September 14, 2023  
Popeye's – Cameron, NC  
Client #C22-129  
1517 NC 24-87  
Cameron, NC 28326

### **Building Department Review response**

Drawing Title  
**COVER SHEET**

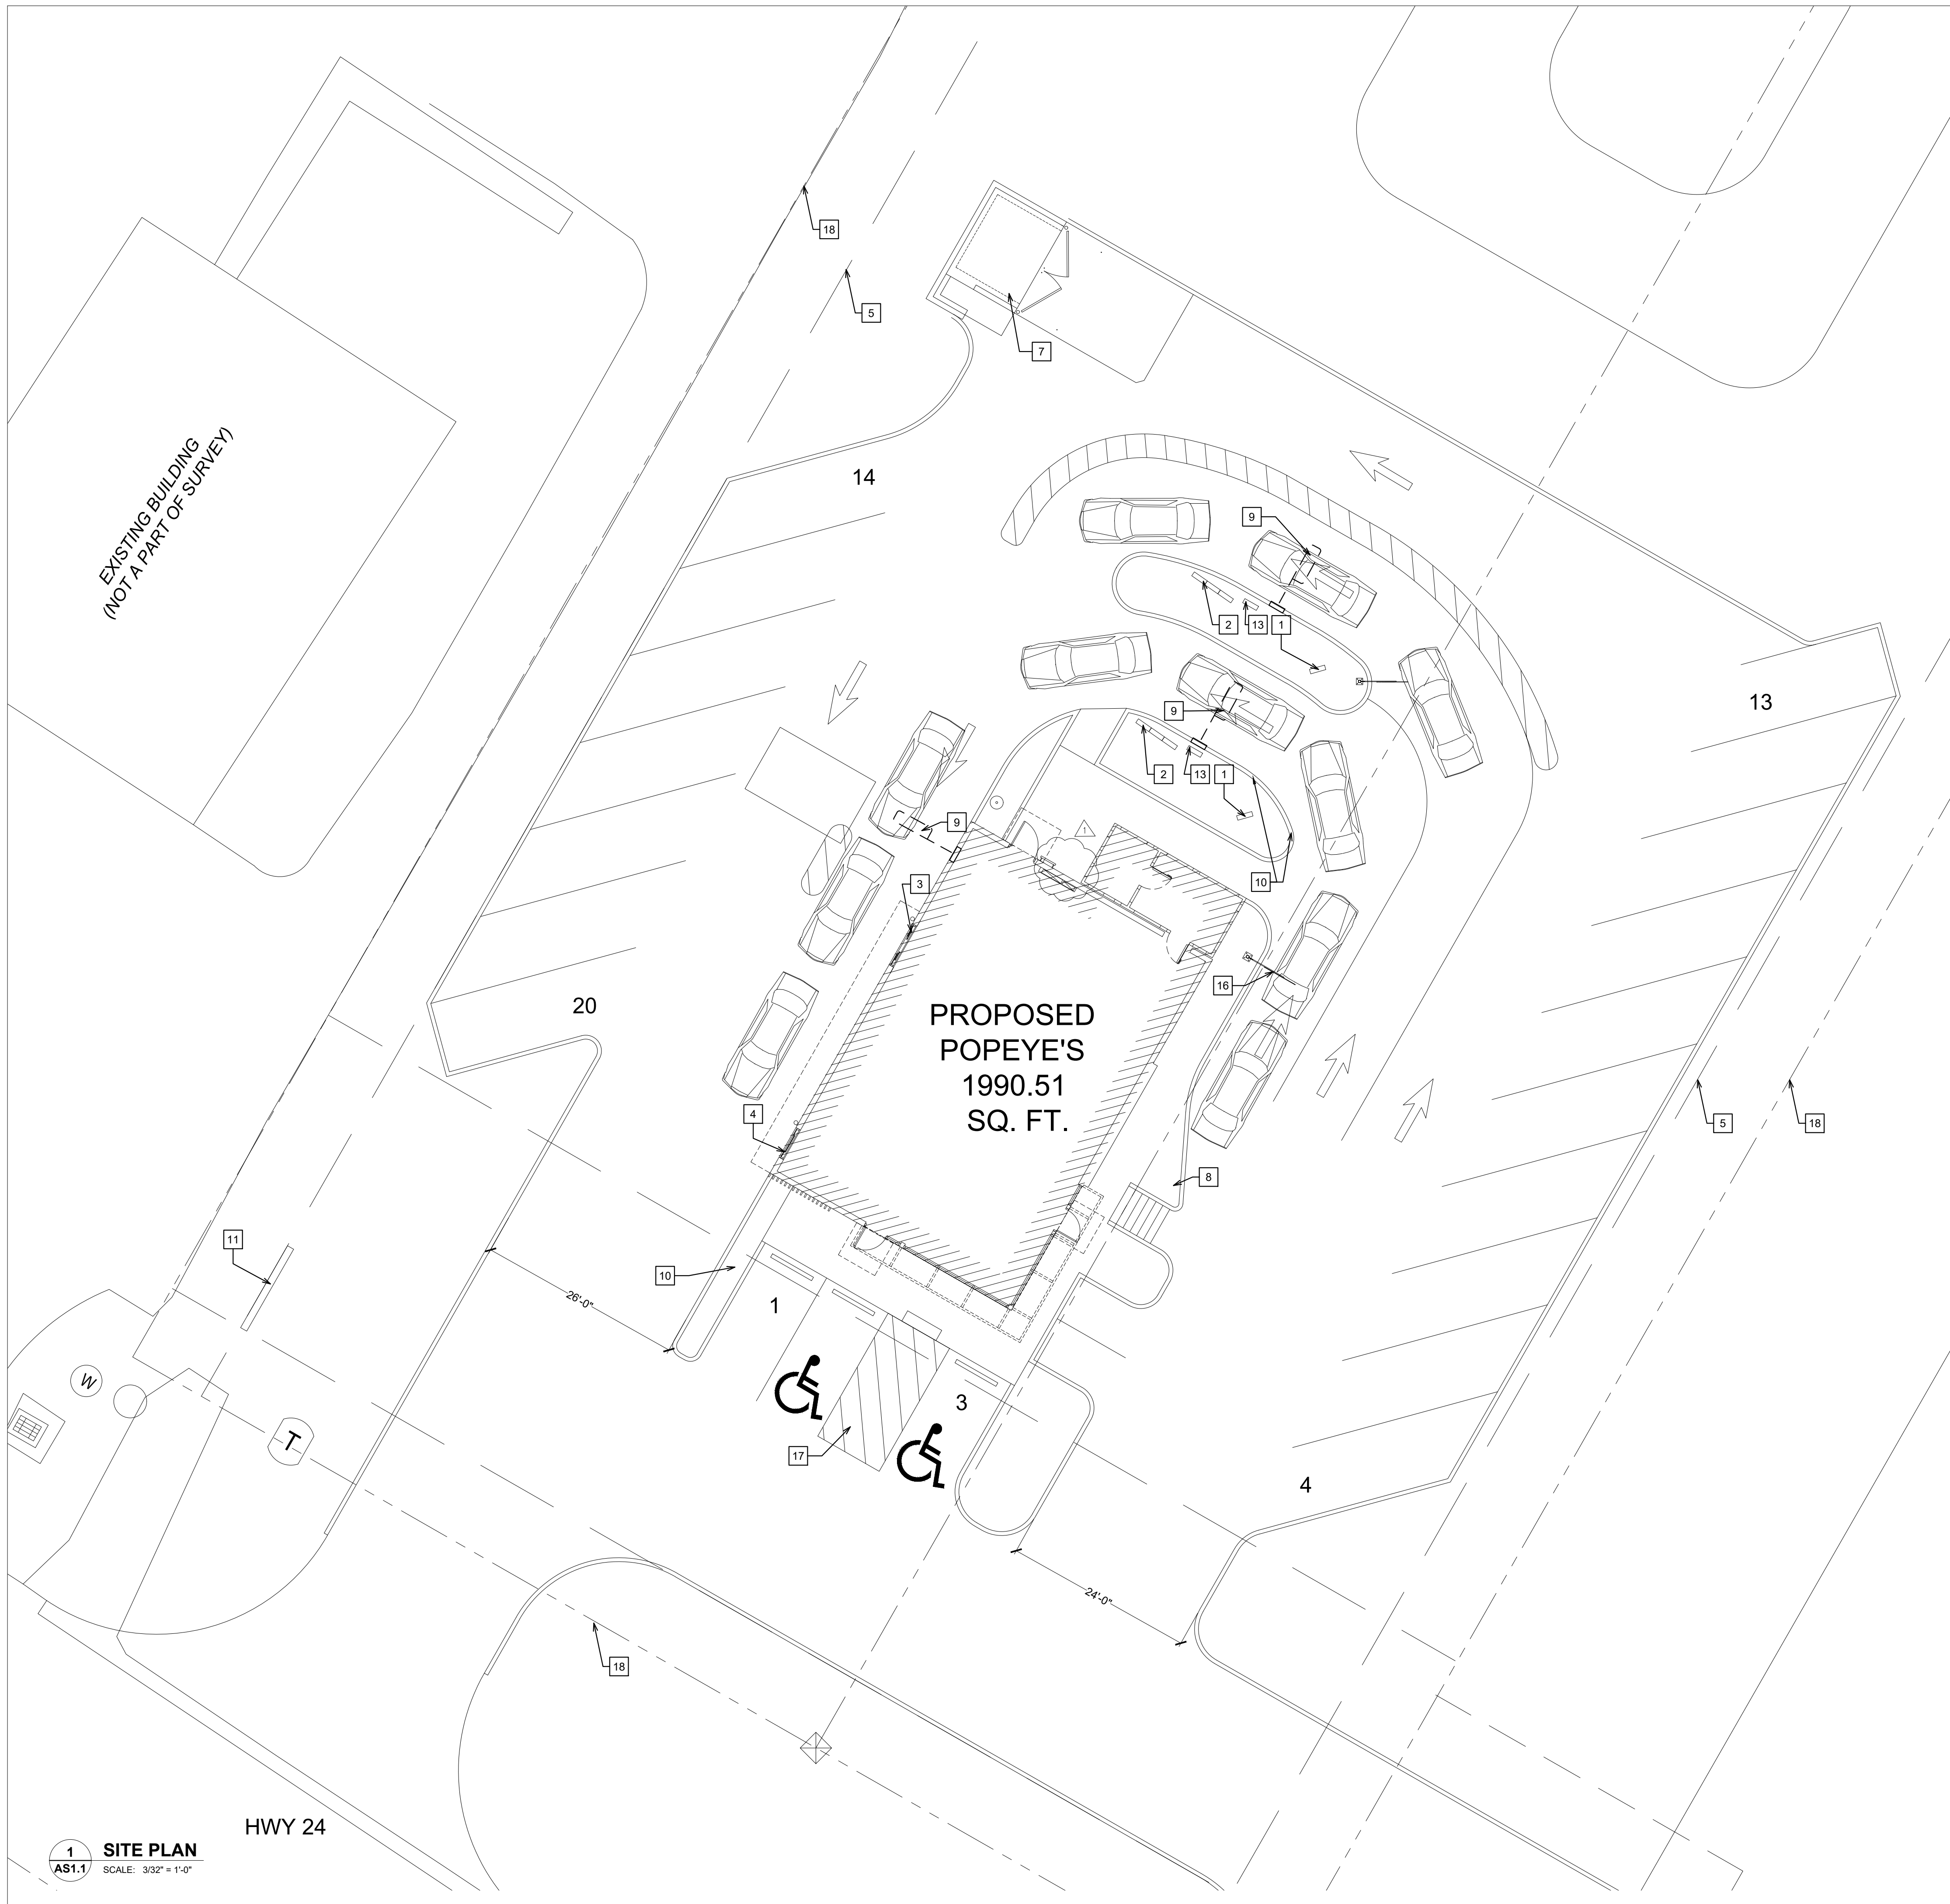
2. Occupant load calculated is 33. Only 1 restroom is shown in the building.

[Acknowledged. Occupancy classification was changed to mixed-use and reclassified to a business and assembly as an accessory space. The occupancy loads were revised based on the new classification. See sheets CS and AS2.4.](#)
